CITY OF ALBUQUERQUE

November 2, 2023

Re: Albuquerque School of Excellence
13201 Lomas Blvd. NE
90-Day Temporary Certificate of Occupancy
Transportation Development Final Inspection
Engineer's Stamp dated 07-20-20 (J22-D050)
Certification dated 02-16-23

ABQ SCHOOL OF EXCELLENCE	DRAWN BY pm
	ADMINISTRATIVE AMENDMENT	DATE 7-20-2020
	TRAFFIC CIRCULATION LAYOUT	DRAWING 2019068-SP
	TIERRA WEST, LLC 5571 MIDWAY PARK PL NE ALBUQUERQUE, NEW MEXICO 87109 (505) 858-3100 www.tierrawestllc.com	SHEET # SP-1
RONALD R. BOHANNAN P.E. #7868		JOB # 2019068

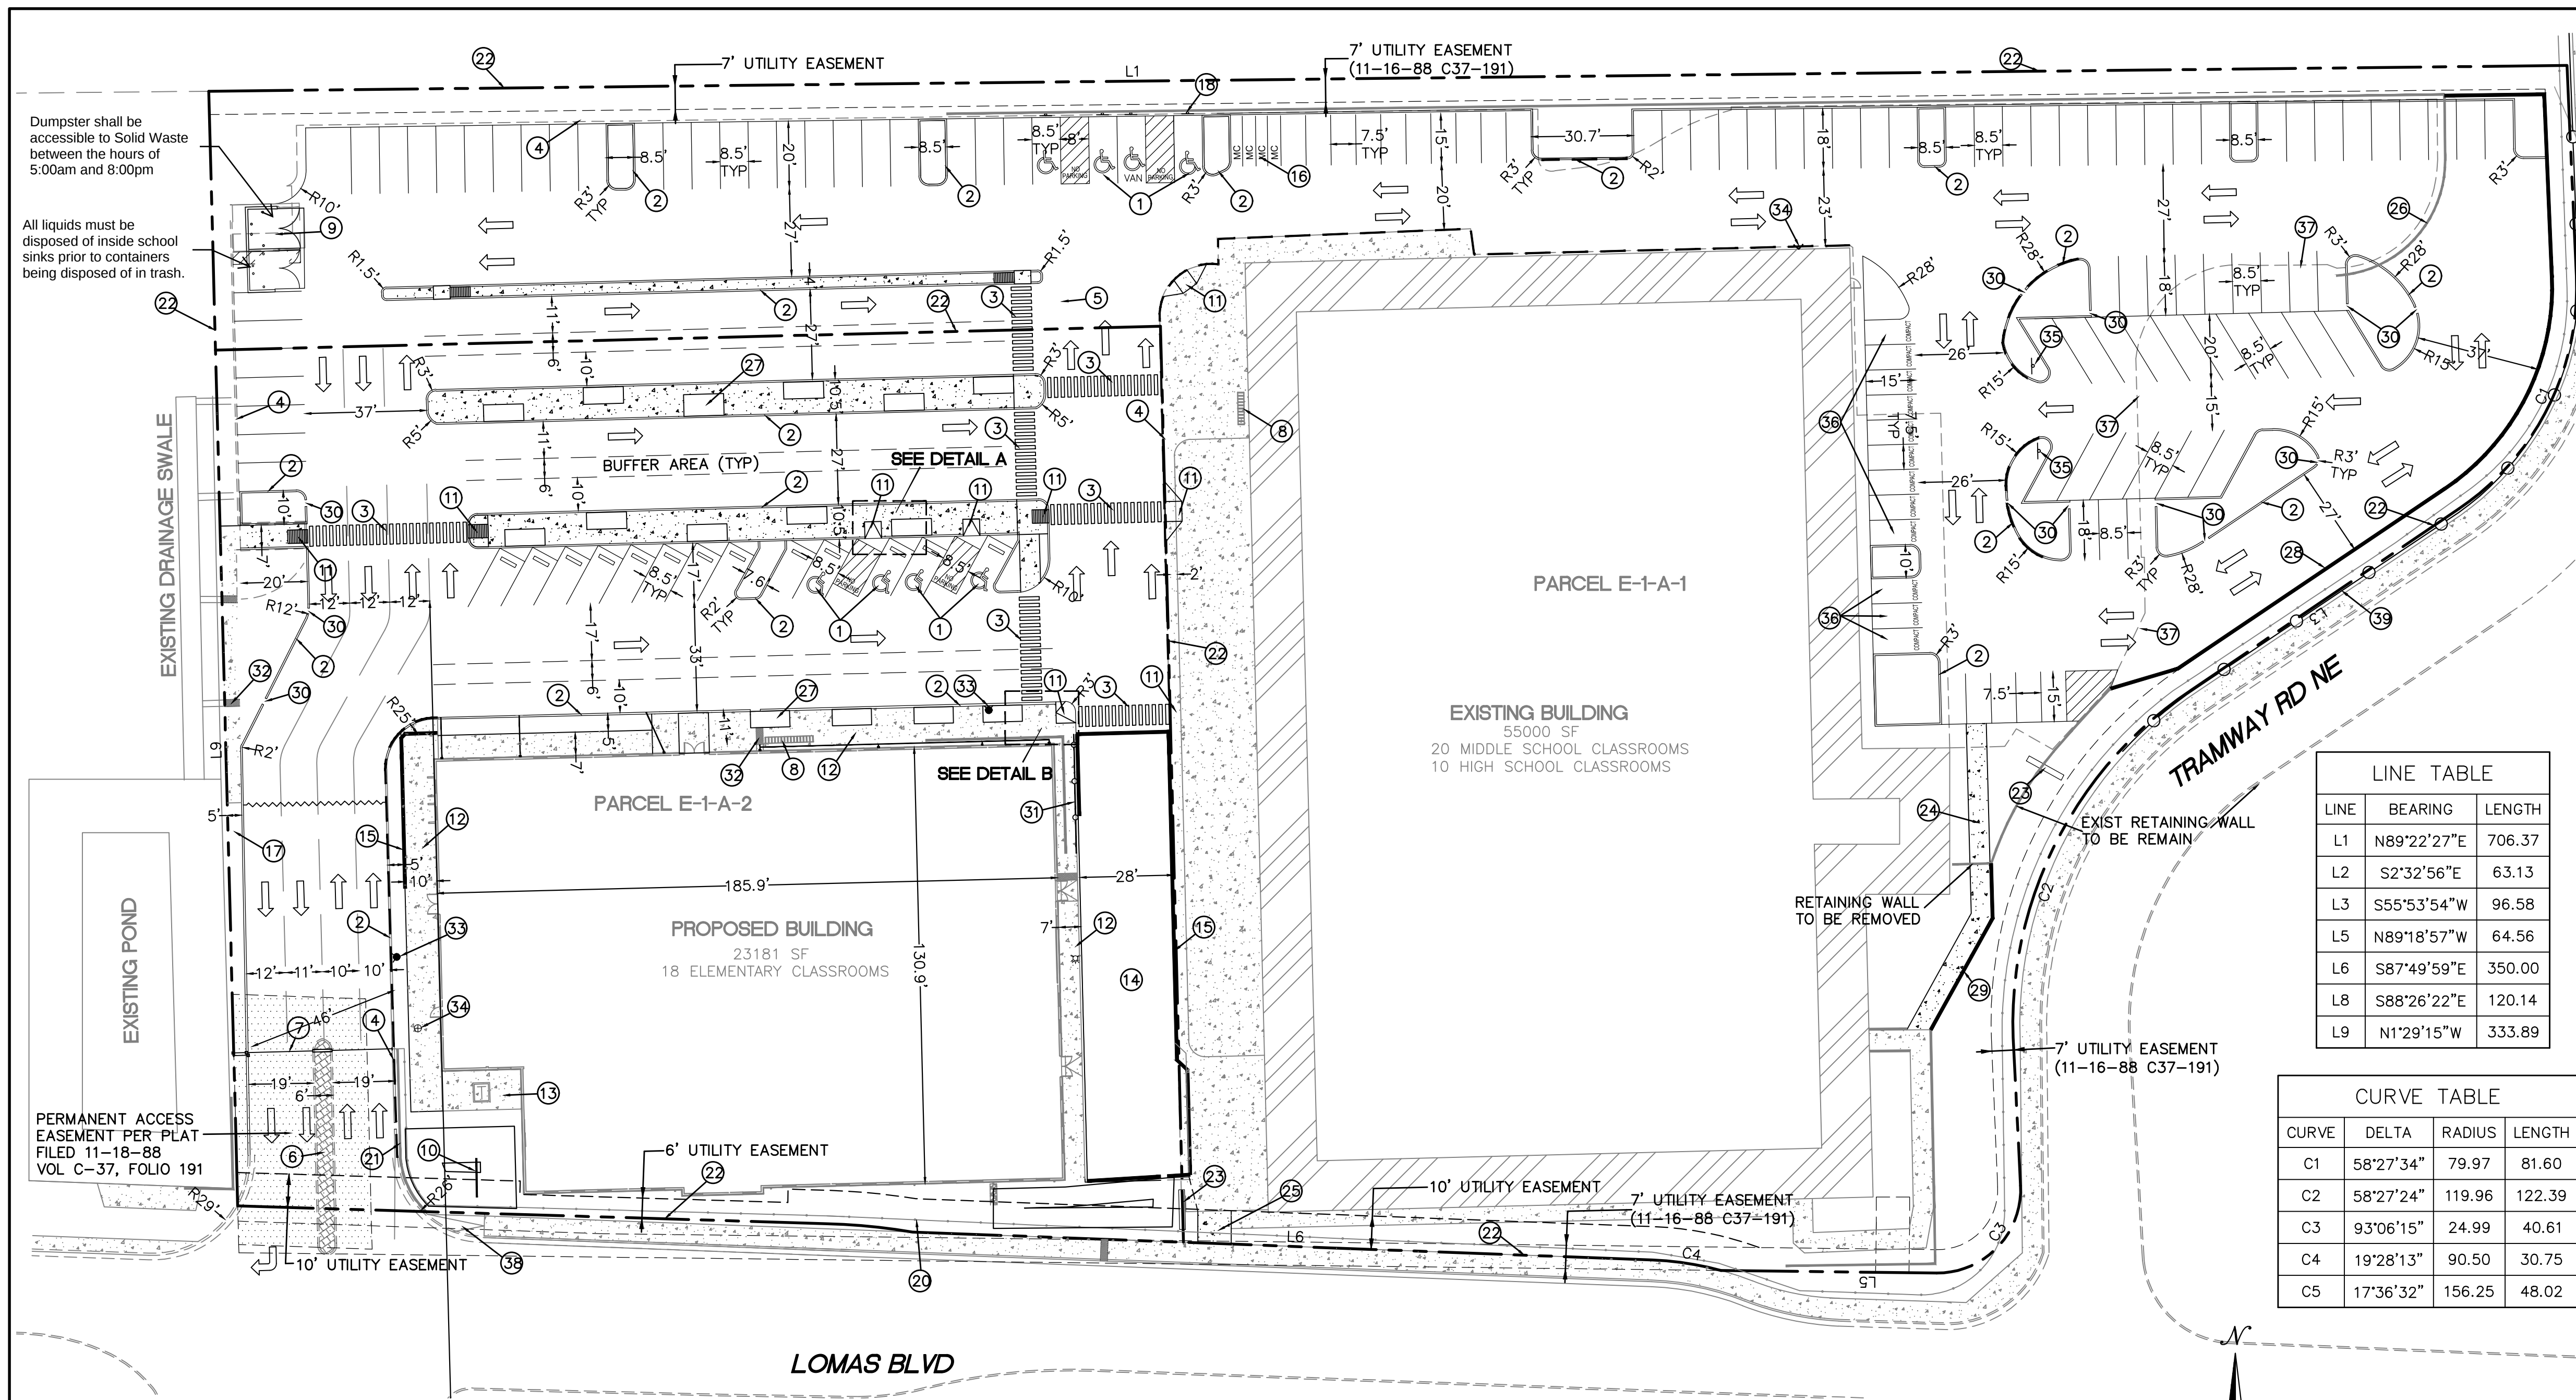
- Please add Truncated Domes to wheelchair ramps in the public right of way.
- Please build the north east side parking spaces per the approved plan, and add the compact parking spaces.
- per site visit, the ADA parking spaces' slope is 6% (at the north side of the site). Per city requirement the slope for the ADA parking spaces and aisles shall not exceed 2% in any direction.
- Key note 11: ADA ramp is missing in those locations. See attached blue-marked site plan.
- Motorcycle parking spaces and signs are missing. Please build MC parking spaces per the approved plan.
- The pavement striping by the Dumpster, and at the north side of the new building are missing.
